Re: Hanson Concrete Plant application at Berth 1 and land adjacent, Glebe Island
Application # SSD 8544

OBJECTION

HANSON EIS REVIEW

Hanson Aggregate Facility & Concrete Plant - Glebe Island									
Drawn	AD	Date	05.03.2018	Scale	1:100	Job No	Glebe Island	Drawing Number	Rev A
Checked	AD	By							
Approved	AD	By

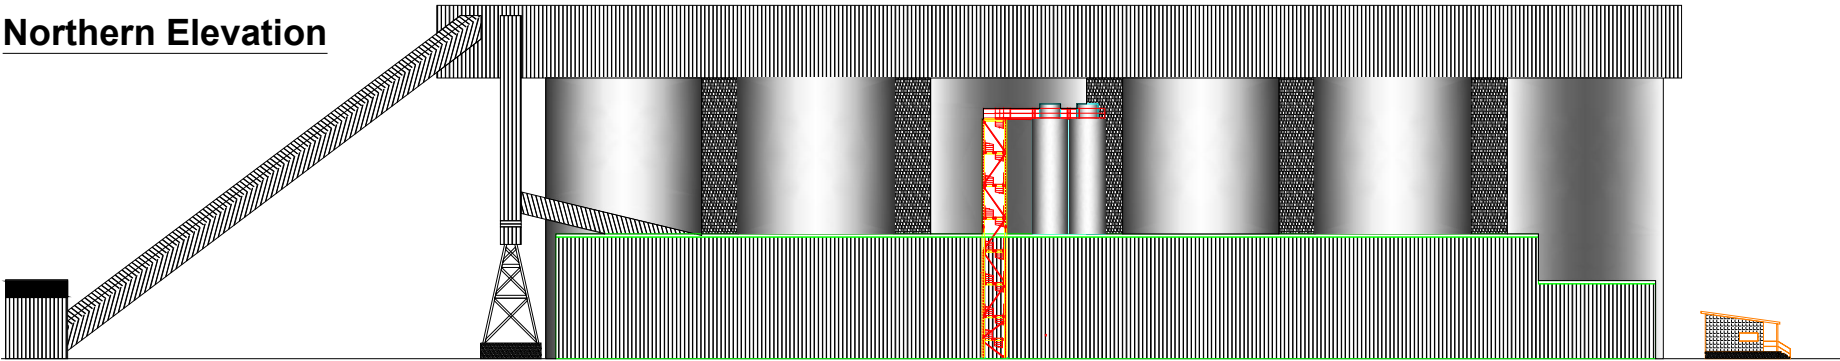
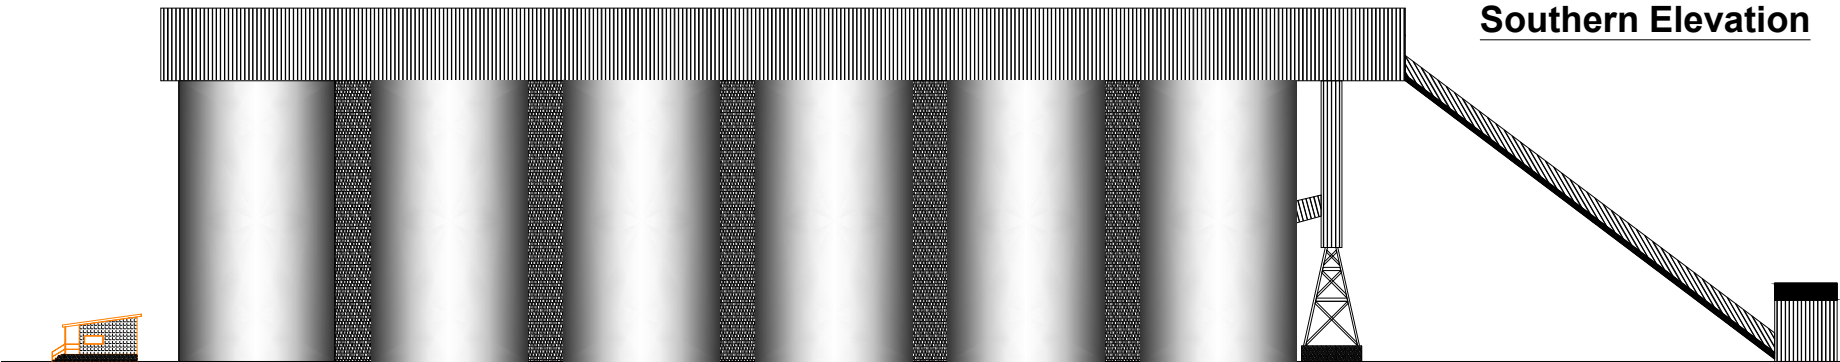
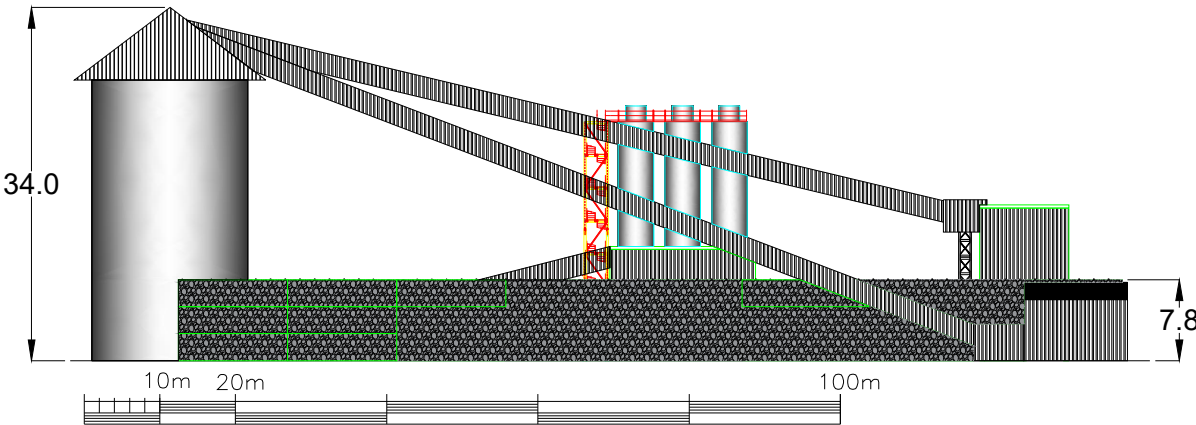
34-metre high silos do not represent a low-profile design sympathetic to its surrounding environs. 34 metres is the equivalent of an 11-storey building! To put this into perspective, Evolve (the apartment building directly opposite the proposed concrete plant) is 12-storeys in height. I understand that the existing Glebe Island Silos are approximately 43m in height. In fact, the scale of this proposal is so large that views of important heritage and iconic buildings such as the Glebe Island Silos and the Anzac Bridge will be obliterated from many vantage points along the public parks and promenades alongside Johnstons Bay. The character of Glebe Island is low-profile. The character of the proposed facility is not.

Comment: The proposed development occupies a site area of over 16,000sqm (approximately 21/2 football fields). The height of the main roof is unclear from the documentation but appears to be around 15m. There are two banks of silos, one (6 silos) being 25m high located in the centre of the building and the other (larger) row of 6 aggregate storage silos along the southern boundary.

As mentioned in the above comments on section 2.2, this is a very large building located close to significant existing landmarks and over-scaling the waterfront. The photomontage in Fig 13 clearly demonstrates the excessive scale of

this development, with silo heights which will appear to be substantially higher than the existing heritage-listed silos to the west when viewed from the water and many other positions in the area.
